Design Review 11.7.18
ccameron, ndonaldson, blyman

TITLE  
**SITE PLAN,  
GILMAN STREET,  
CONGRESS STREET  
EXPANSION**

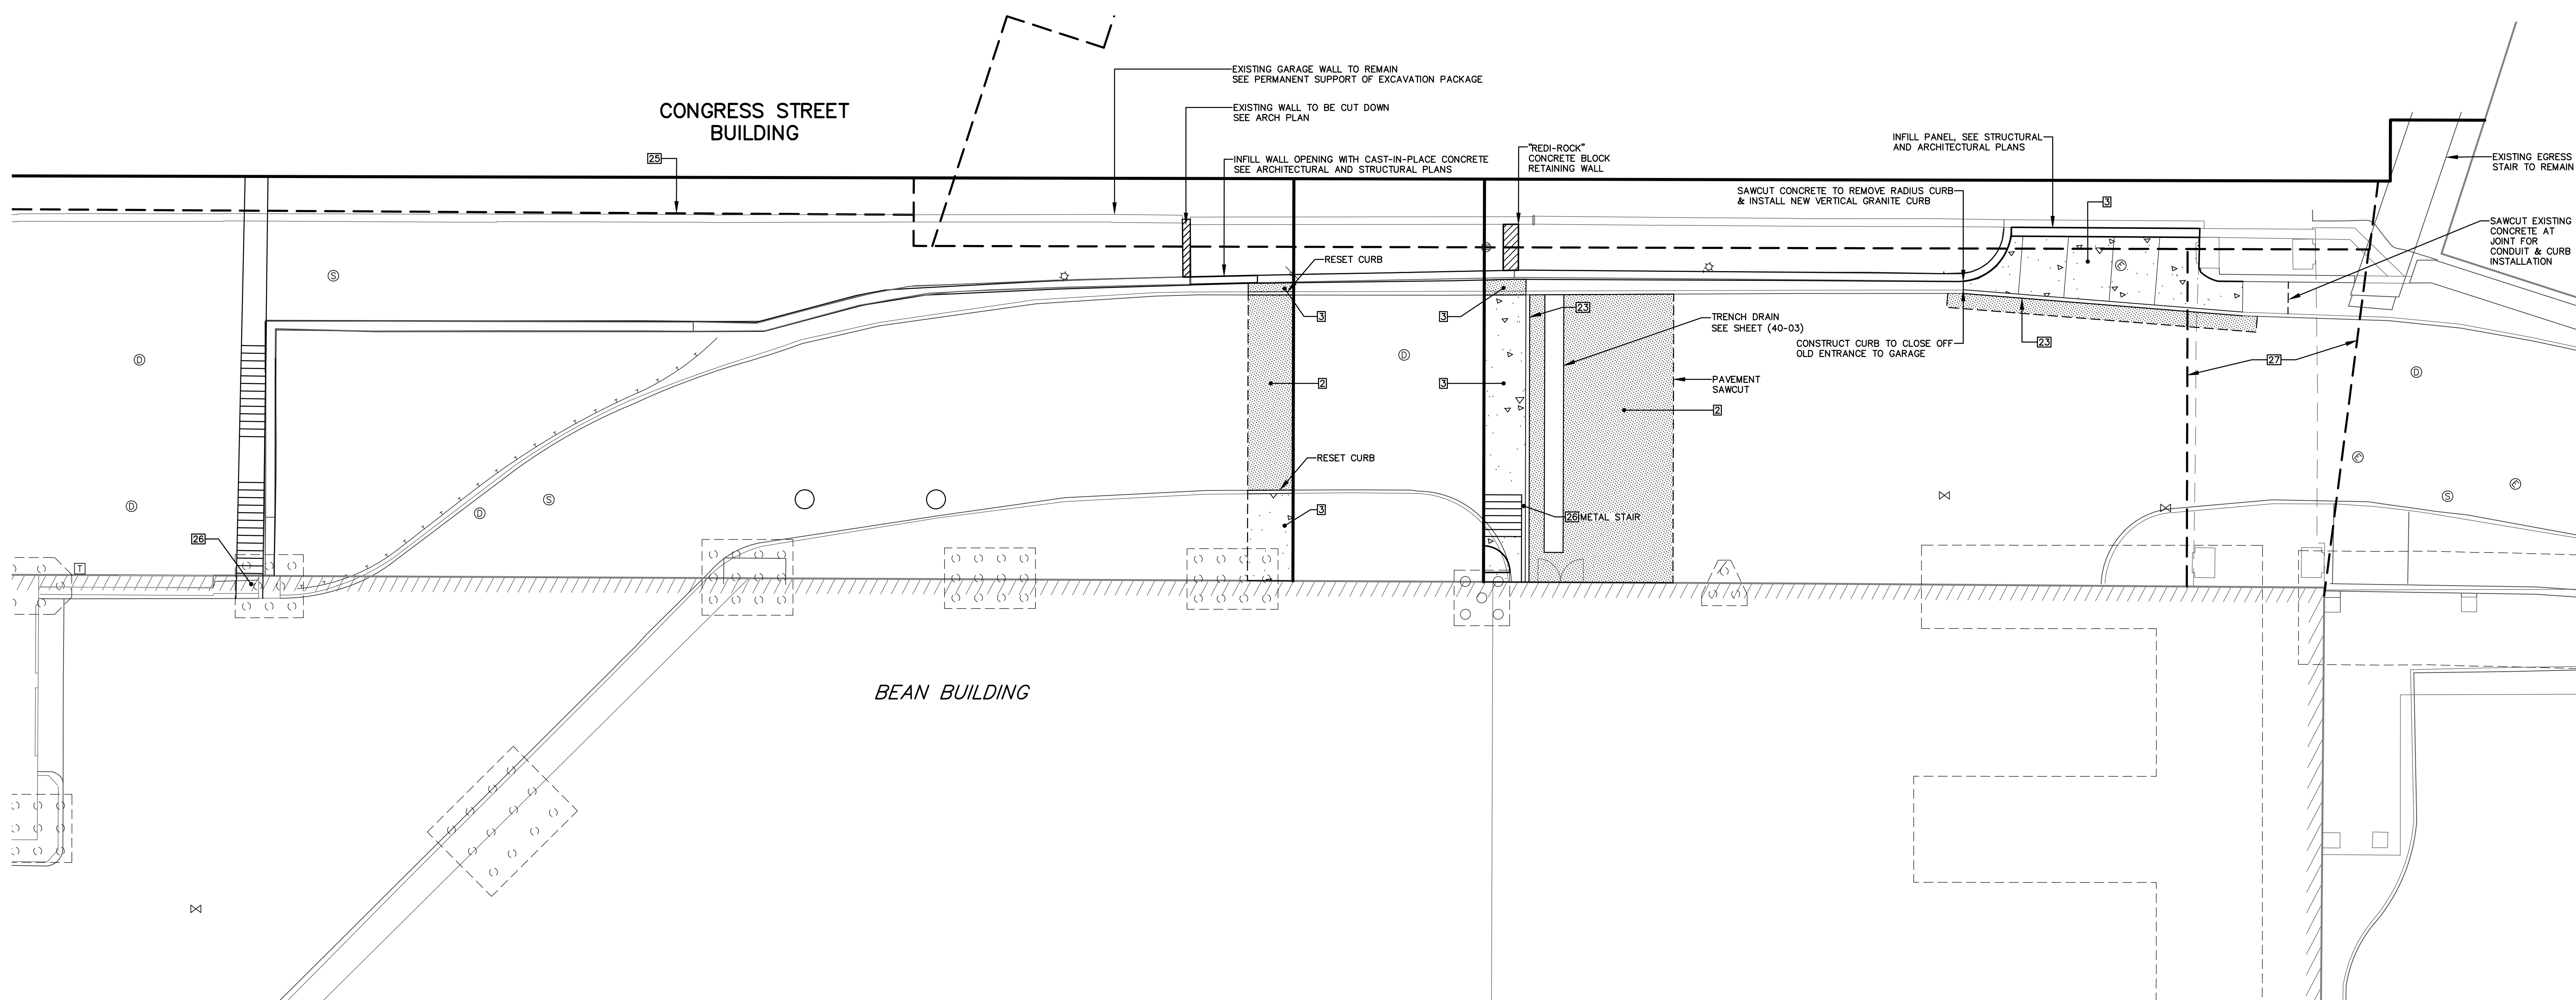
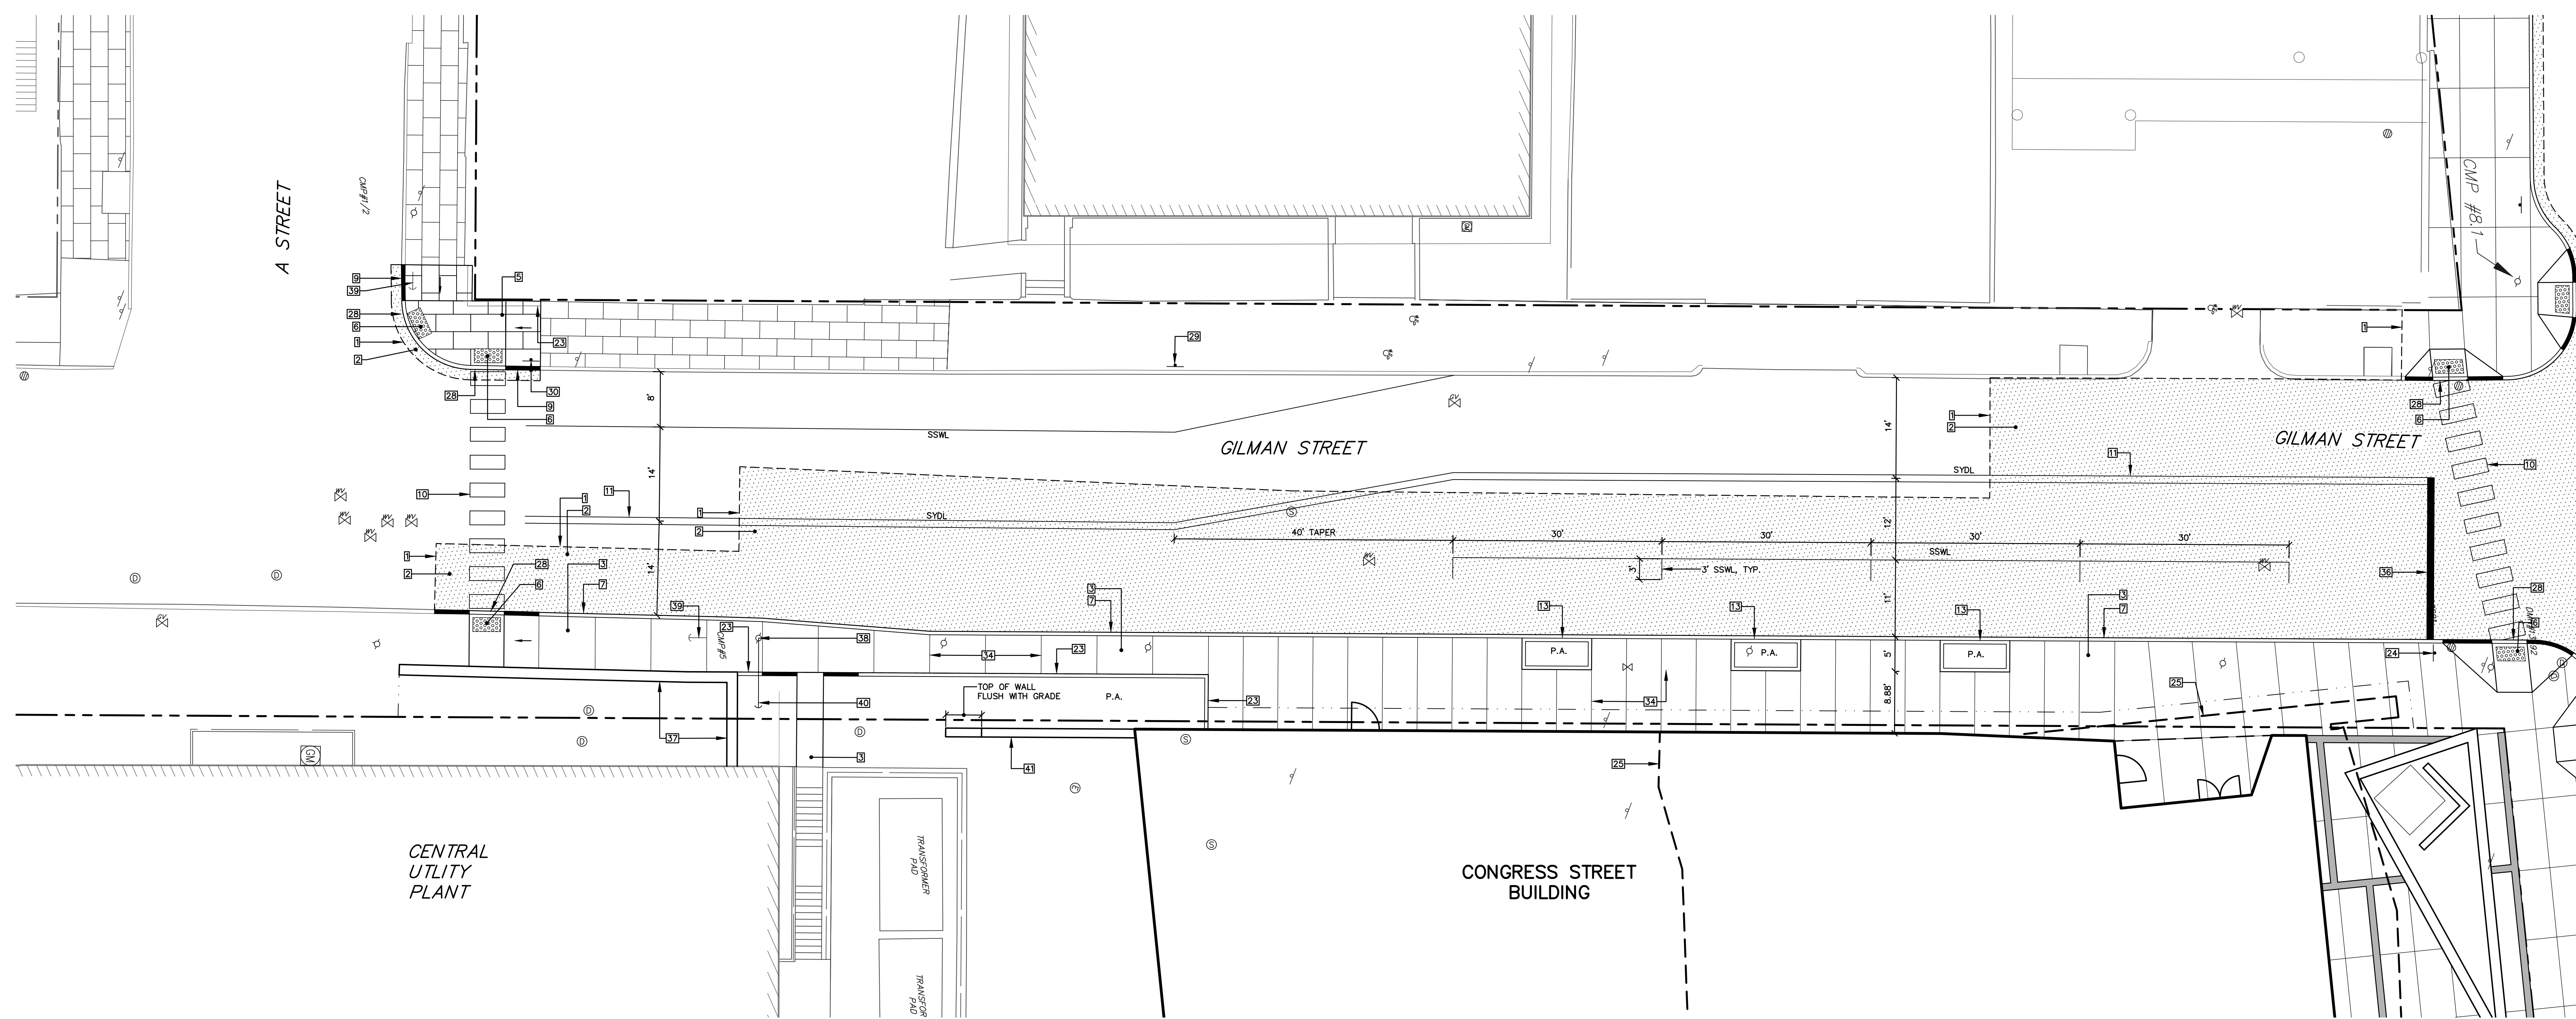
Show street trees on Gilman w/ correct tree well design
